PORTLAND, MAINE PRESERVATION BOARD

November 13, 2017

Re: 14 Marshall Street – Dormer Addition
CBL: 063 C022

Street Elevation Existing

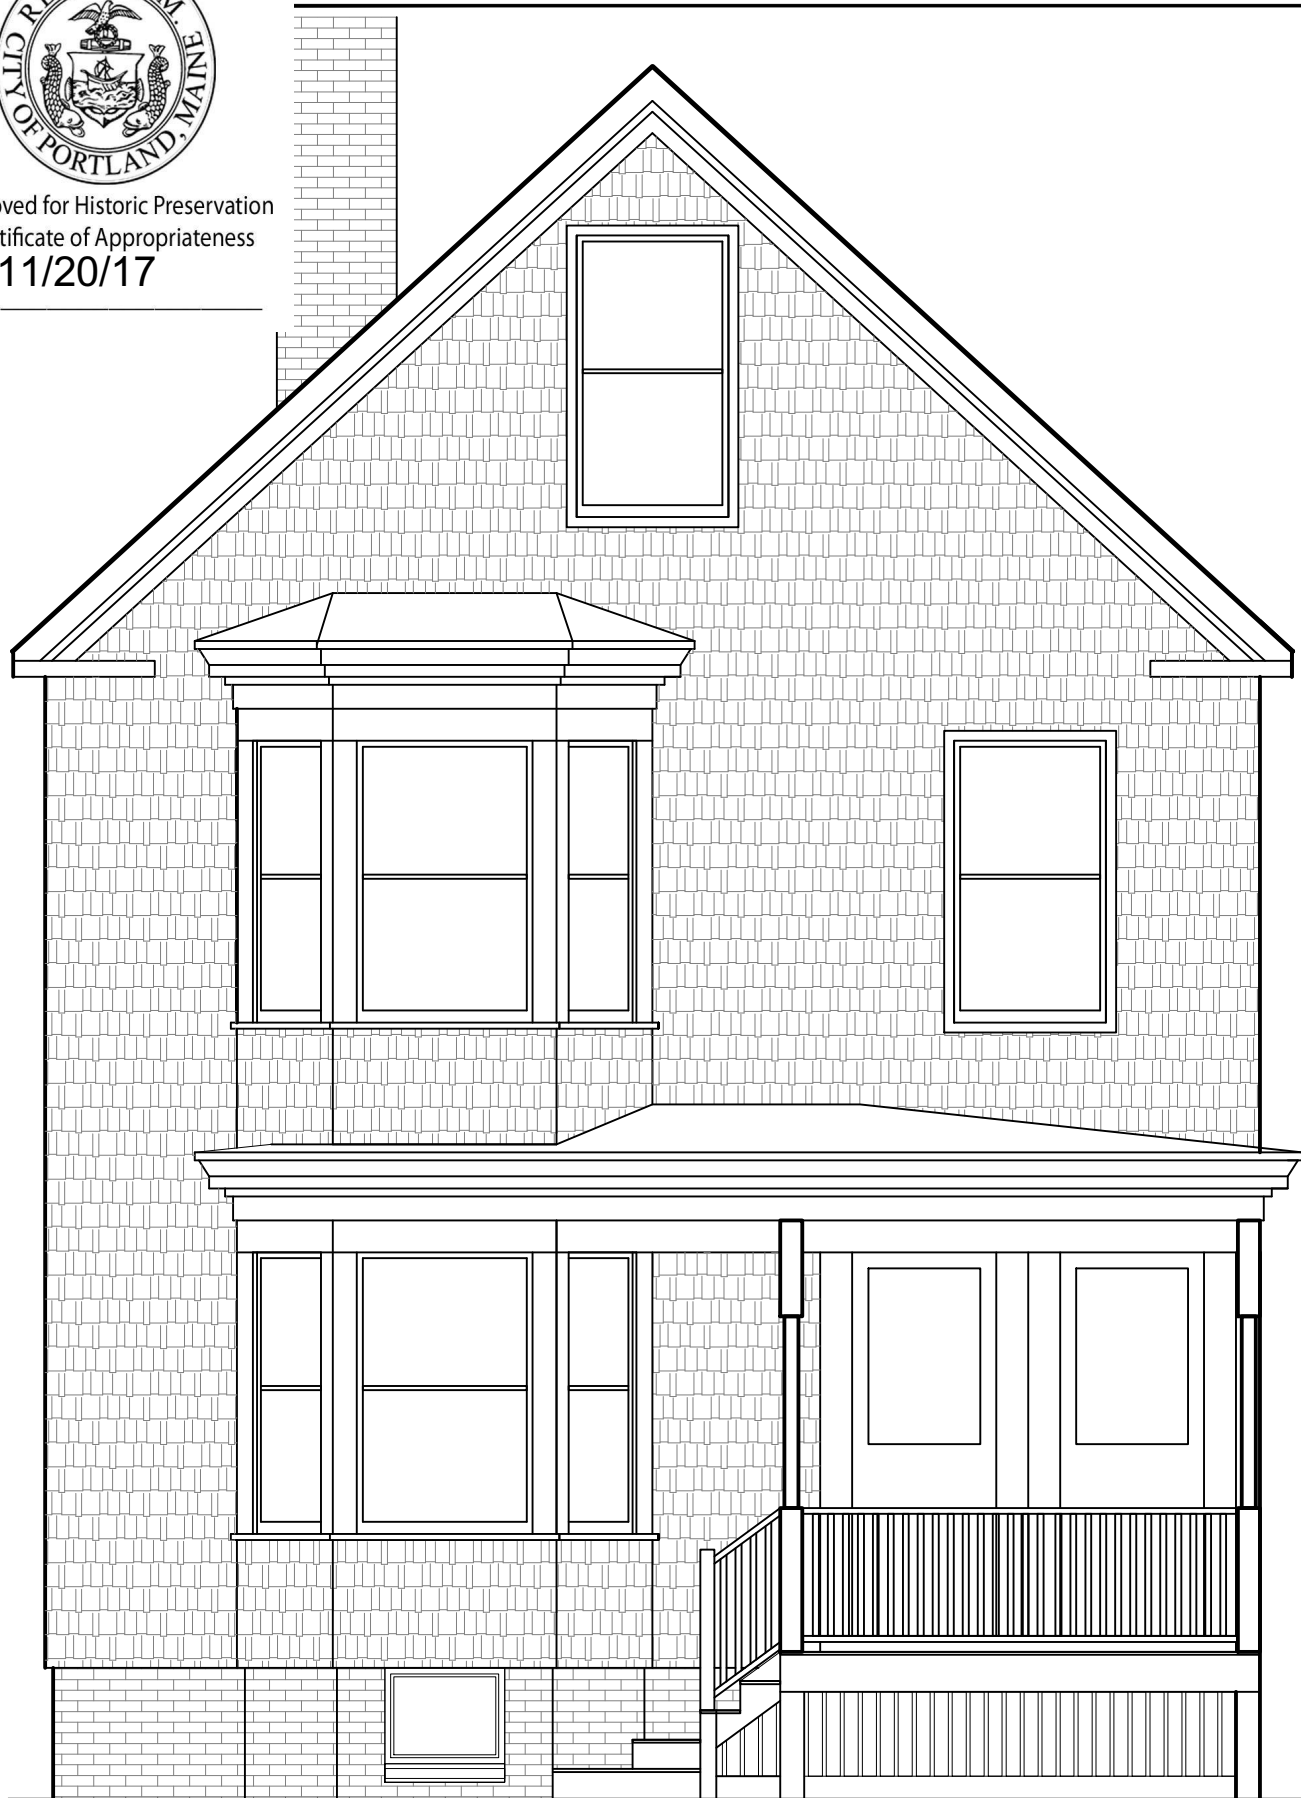
- The kitchen window is to be the same width as the bathroom window, to reduce the number of different window sizes in the dormer and to be consistent with the more vertically oriented proportions of other windows

All improvements shall be carried out as shown in the plans and specifications submitted to HP staff, except as specified above. In addition, please submit to staff a revised elevation and plan (including window revision and trim details) for review and approval, as well as a sample of the siding material.
